Neil McBride
Head of Planning
Planning Services
Lincolnshire County Council
County Offices
Newland
Lincoln LN1 1YL

Date: 15 November 2024

Application by Tillbridge Solar for an Order Granting Development Consent for the Tillbridge Solar Project

Following the Planning Inspectorates Rule 8 letter dated 22 October 2024 the County Council submits its written representation in respect of this application. The Council provided initial comments in relation to this application in its Relevant Representation response earlier this year.

**Figure 15-1: Principal Site Agricultural Land Classification  
Distribution**

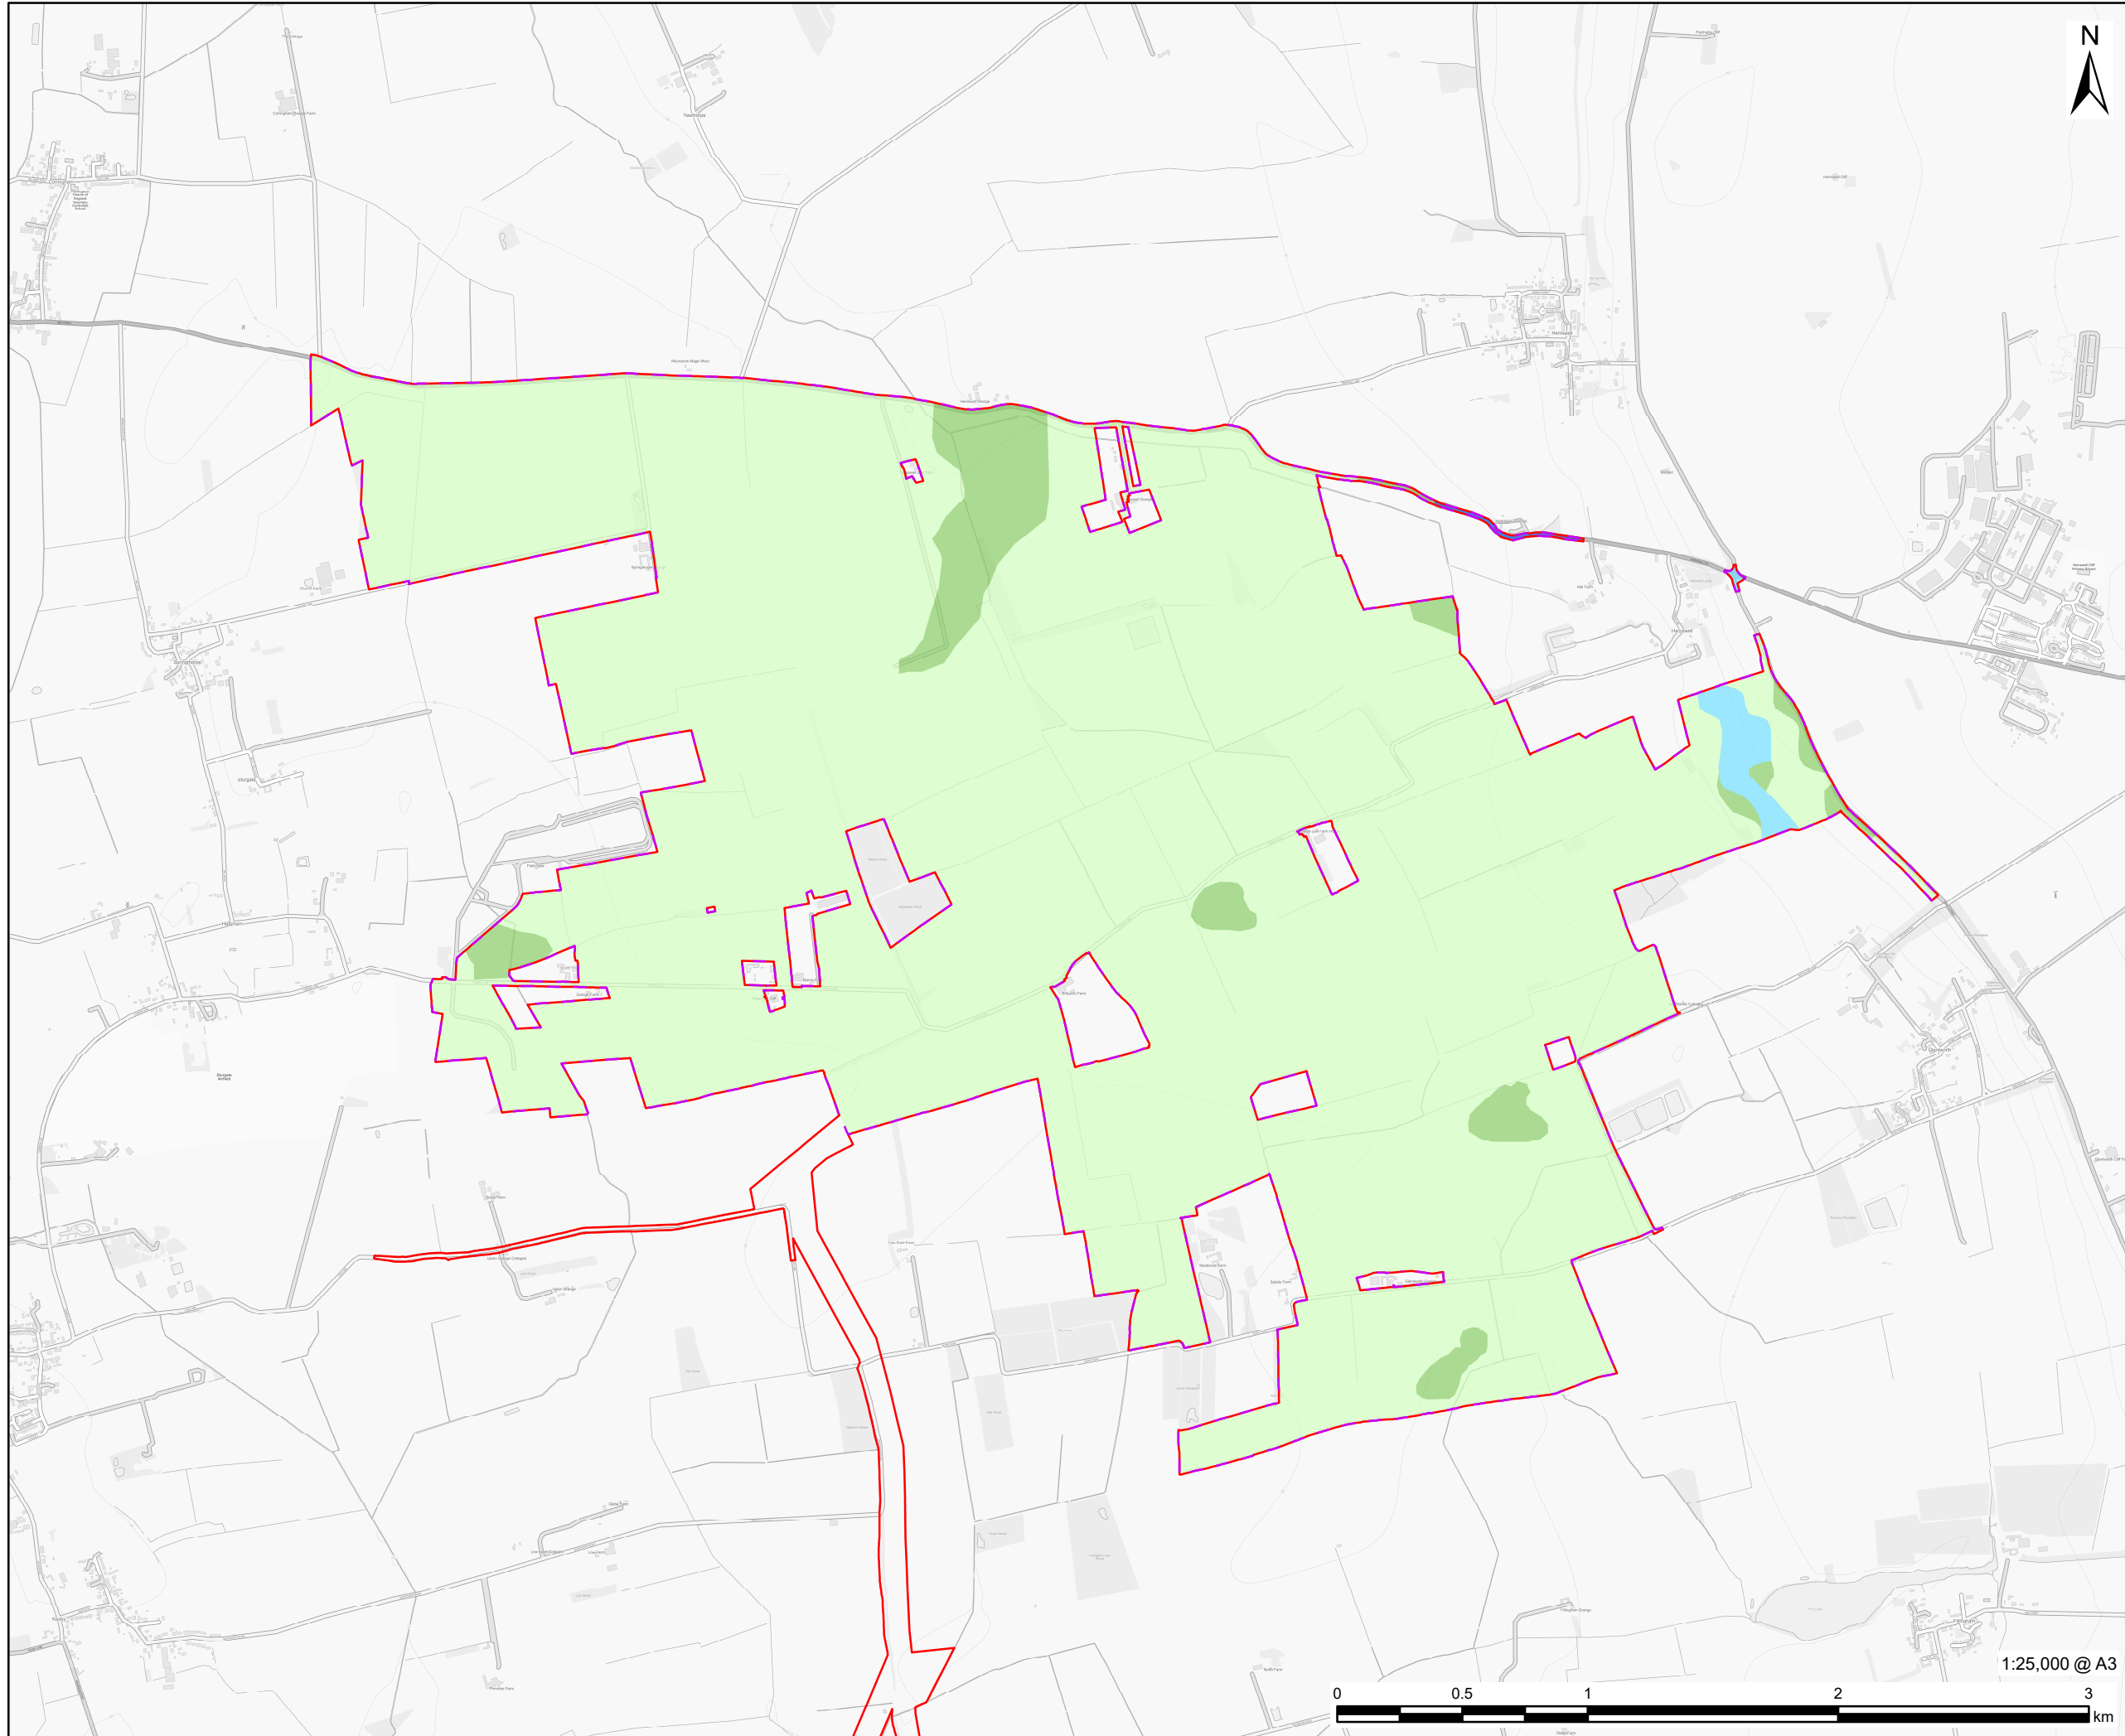
There is a tension in relation to BMV impacts given that land in and around of the energy park site comprises land in Grades 1,2 or 3a and a full survey of the cable route as yet to be assessed but is predicted to be around 50-60% BMV. The National Policy Statements direct that previously developed land, brownfield land, contaminated land, industrial land and non-BMV land should be developed as a preference, and where policies S14 and S67 of the CLLP seek to protect the best and most versatile agricultural land so as to preserve opportunities for food production and the continuance of the agricultural economy. A significant permanent and negative impact as a consequence of the loss of agricultural land is identified, a proportion of which of which is classed best and most versatile land. This loss is not only at a local level but significant when considered in-combination with the loss of land from other NSIP scale solar developments that are also being promoted and considered across Lincolnshire contrary to Policy S67.
